June 19, 2019

**Re: Inspiration Subdivision
Erosion and Sediment Control Plan
Engineer's Stamp Date 5-31-19 (J08E005)**

Based upon the information provided in your submittal received 6-13-19, the above referenced plan is not approved to be included in the SWPPP or for NOI documentation review for grading and Work Order until the following comments are addressed:

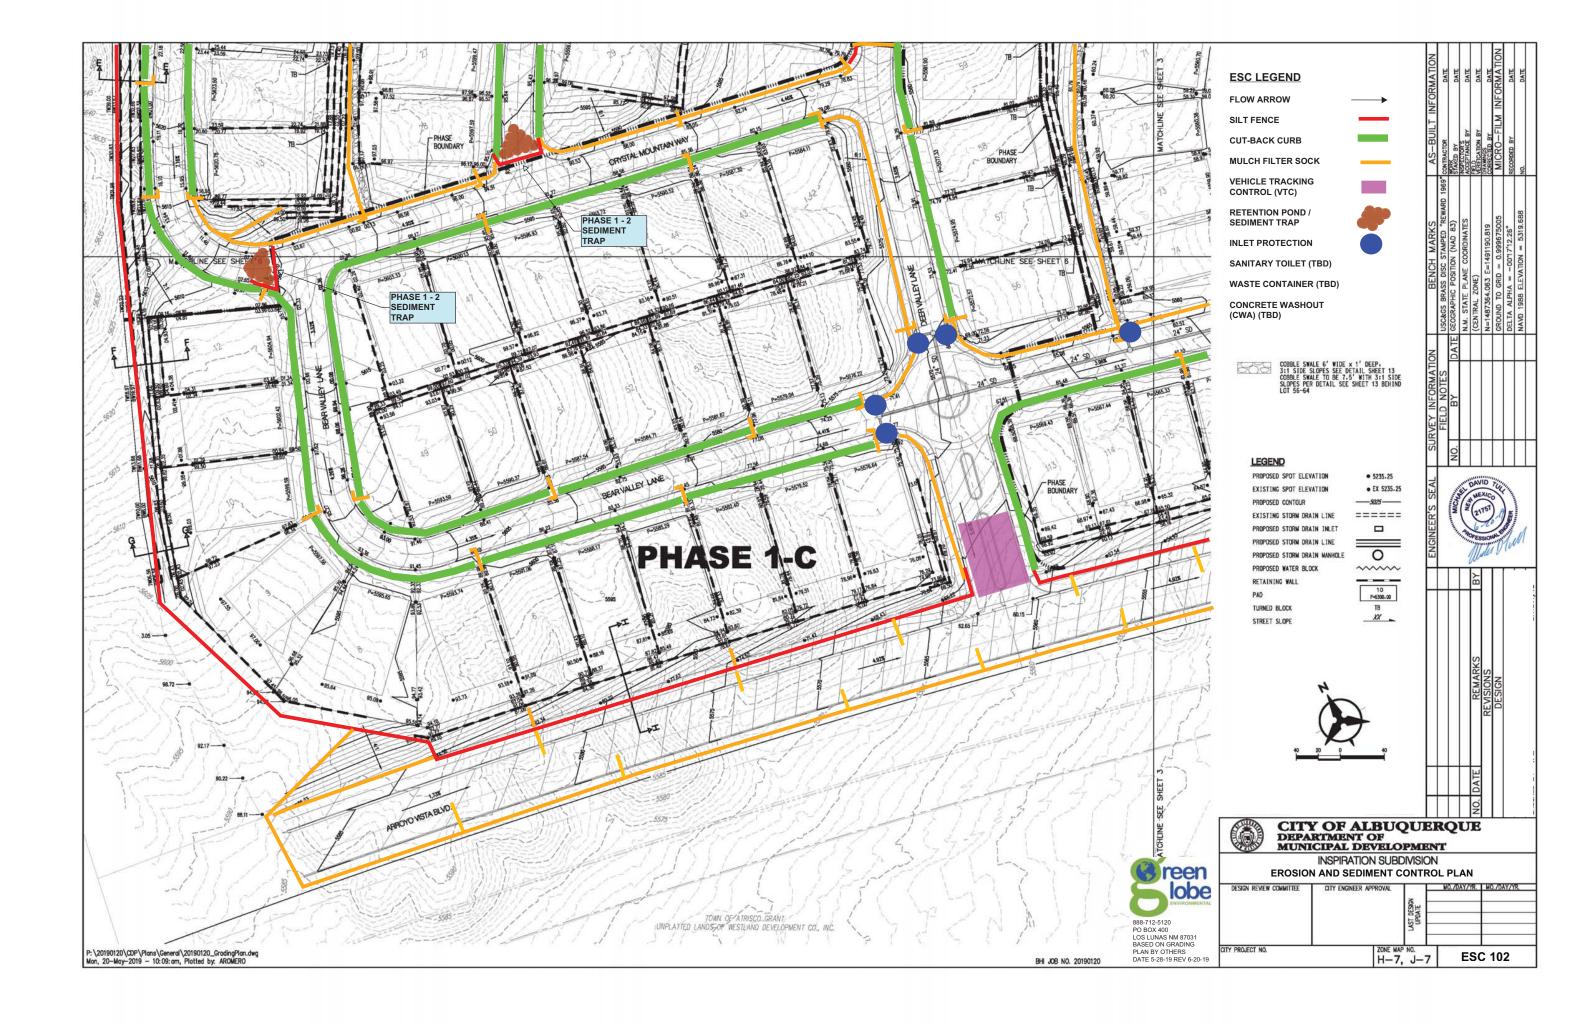
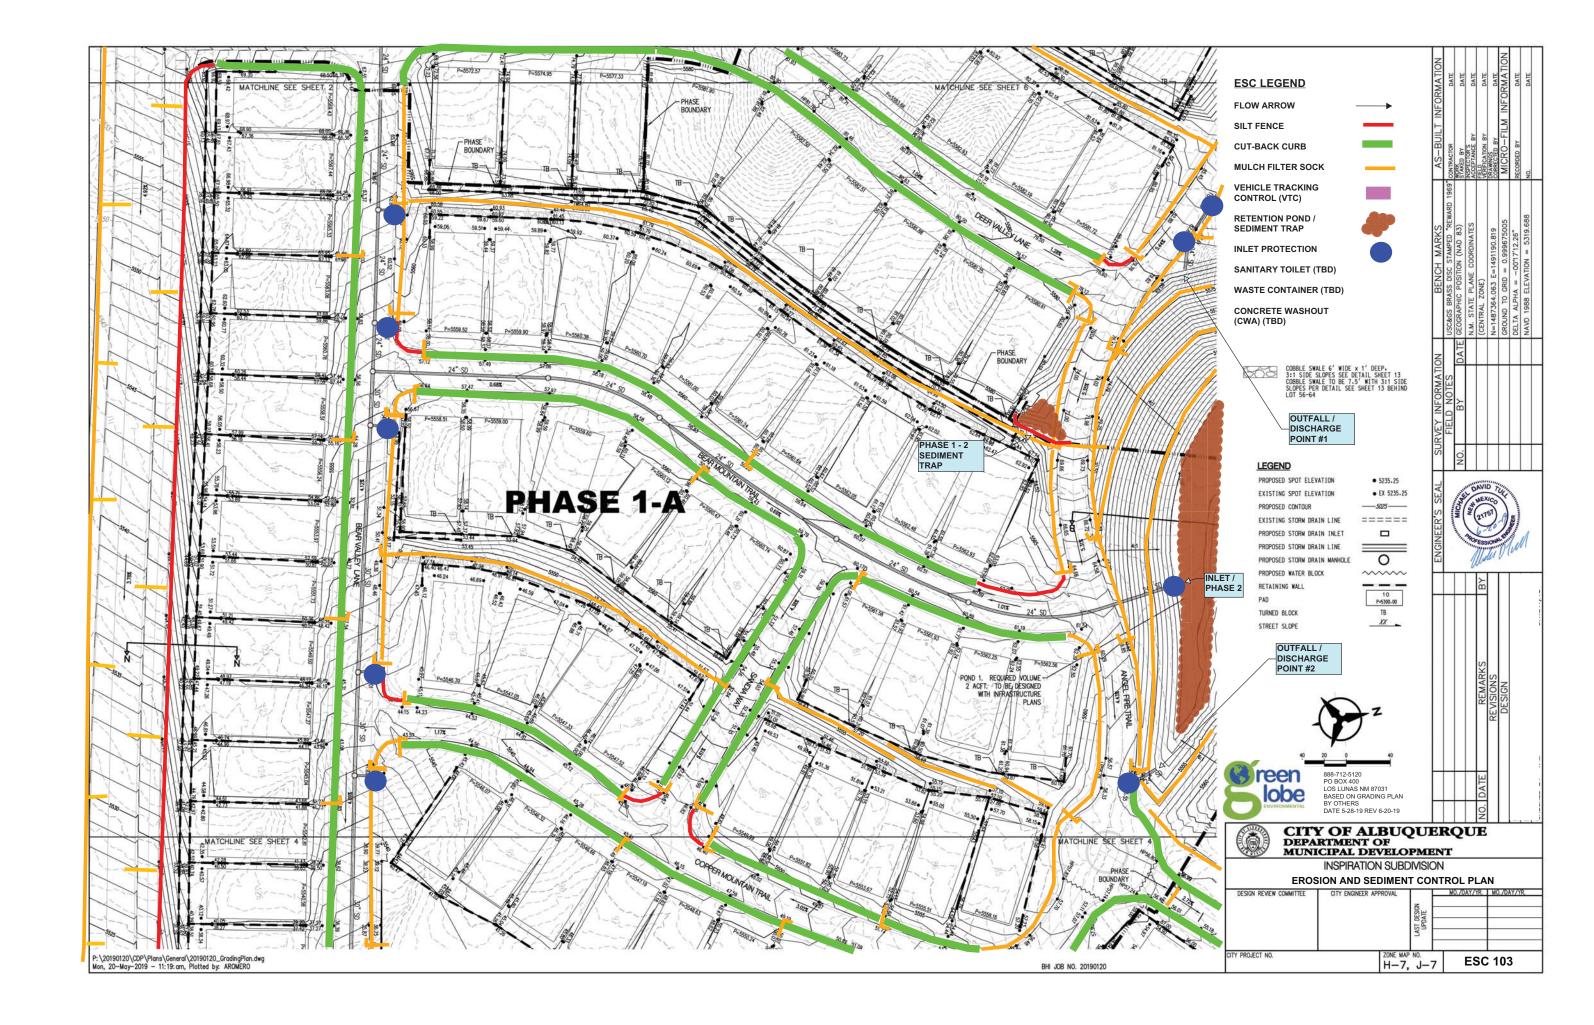
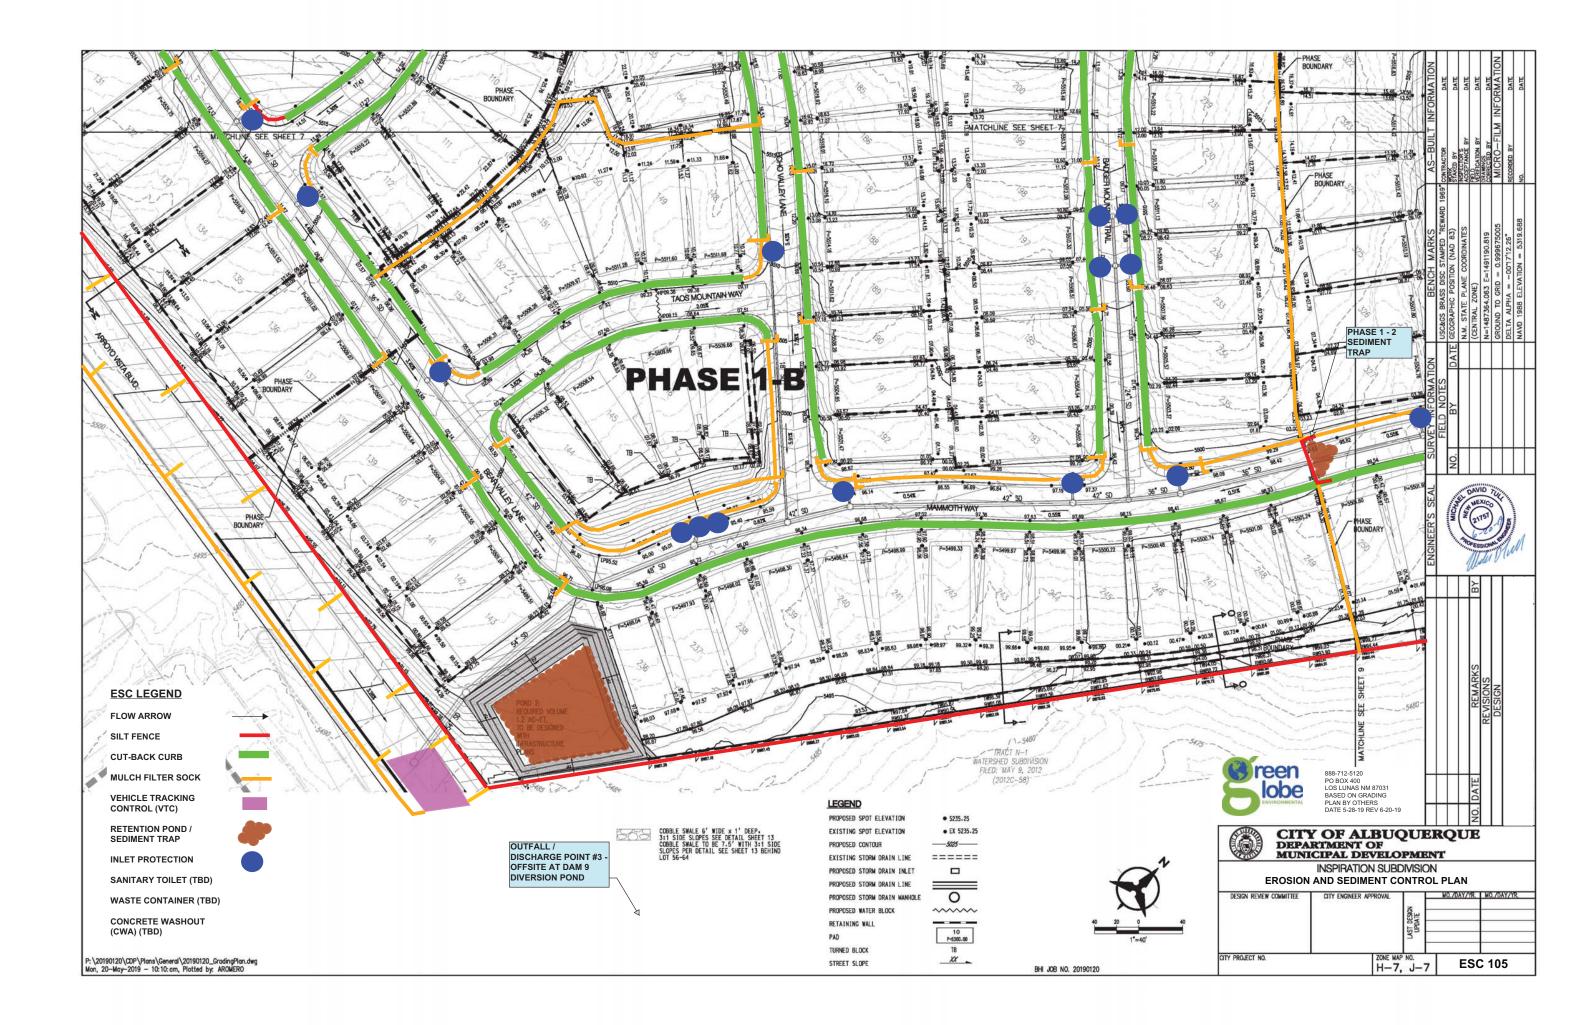
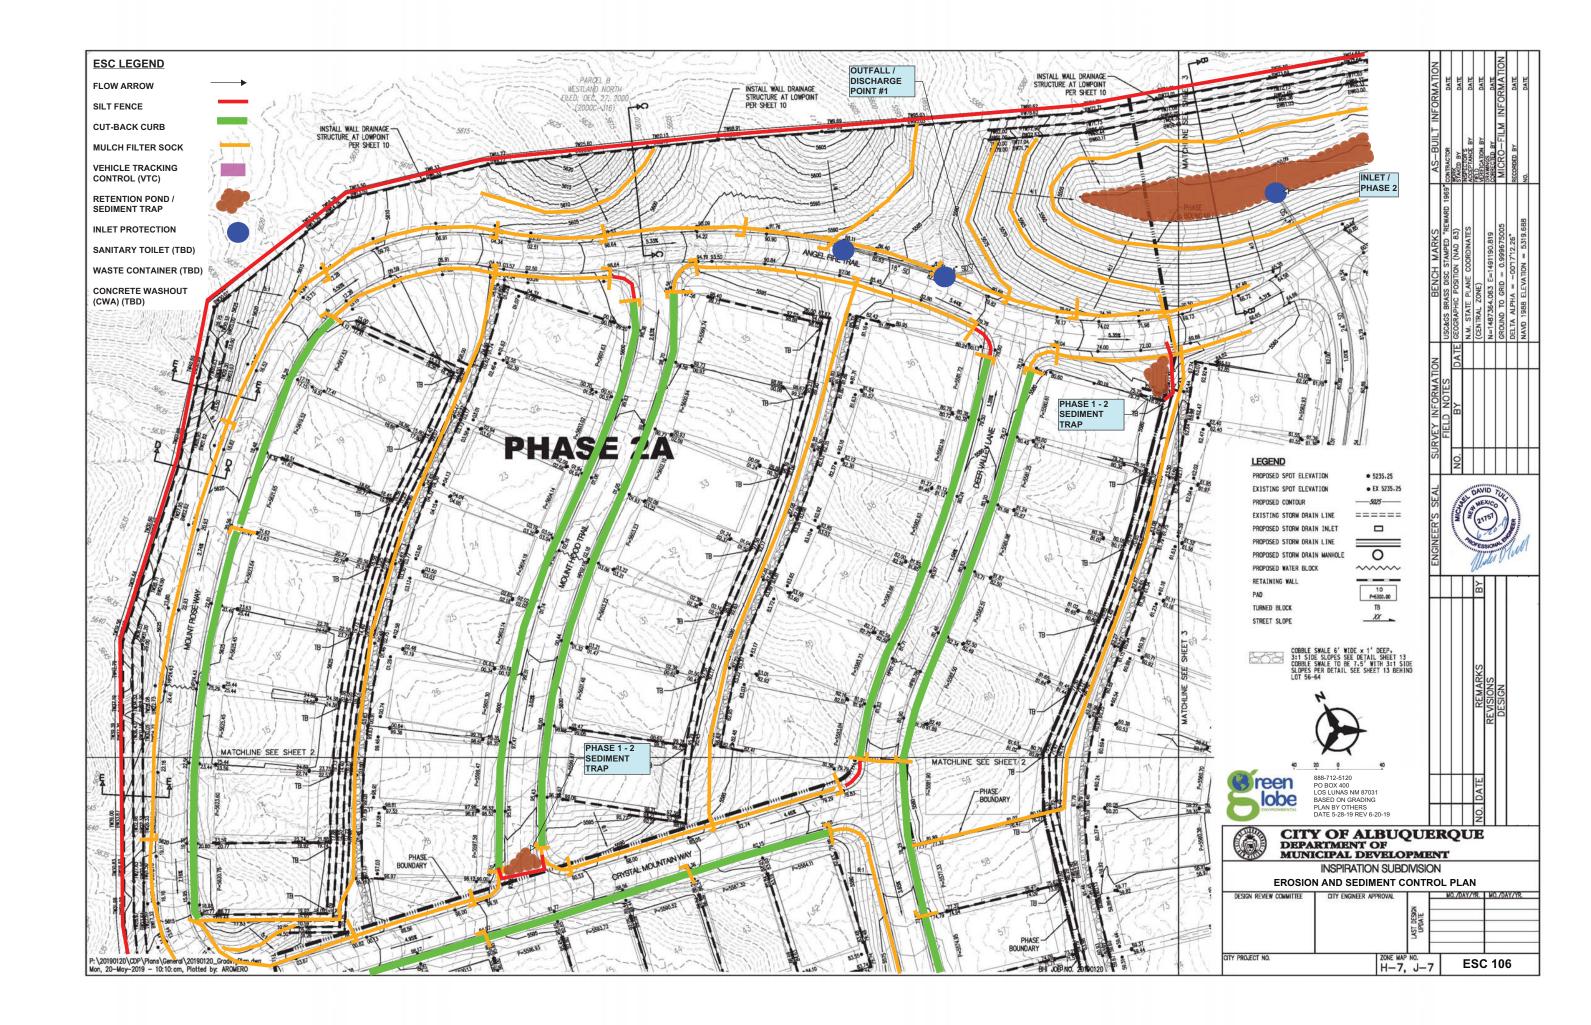
1. The site is large and the plan sheet size is small. Provide the plan on 24" x 36" sheets.
2. The plan does not provide BMPs for and does not show the disturbance area for the grading south of Arroyo Vista Blvd for pond improvements.
3. The slope of Arroyo Vista Blvd is approximately 4%. Propose BMPs so that sediment laden flows will not enter the paved portion of the street. A pond(s)/filter socks on the south side of the road (outside construction vehicle travel path) may help. See image below.

4. Per discussion with Kevin Patton at Pulte Homes, infrastructure for Phase 1-A through 1-C will be constructed first. Propose sediment ponds to prevent sediment from leaving Ph 2 and entering the paved portions of Ph 1 on Mount Hood and Mount Rose streets.
5. Why is there VTC proposed at the west end of Arroyo Vista Blvd? If vehicles will be exiting the site in this location then BMPs will be required for the disturbance caused by the vehicles.
6. The detail for the stabilized construction entrance/exit does not show filter fabric below the aggregate. The filter fabric helps prevent the aggregate from getting pushed into the soil and decreases maintenance of the BMP.
7. Provide inlet protection for the pipe that drains the pond located at the north end of the site (Bear Mountain Trail). A similar condition would apply to all ponds with a discharge pipe.
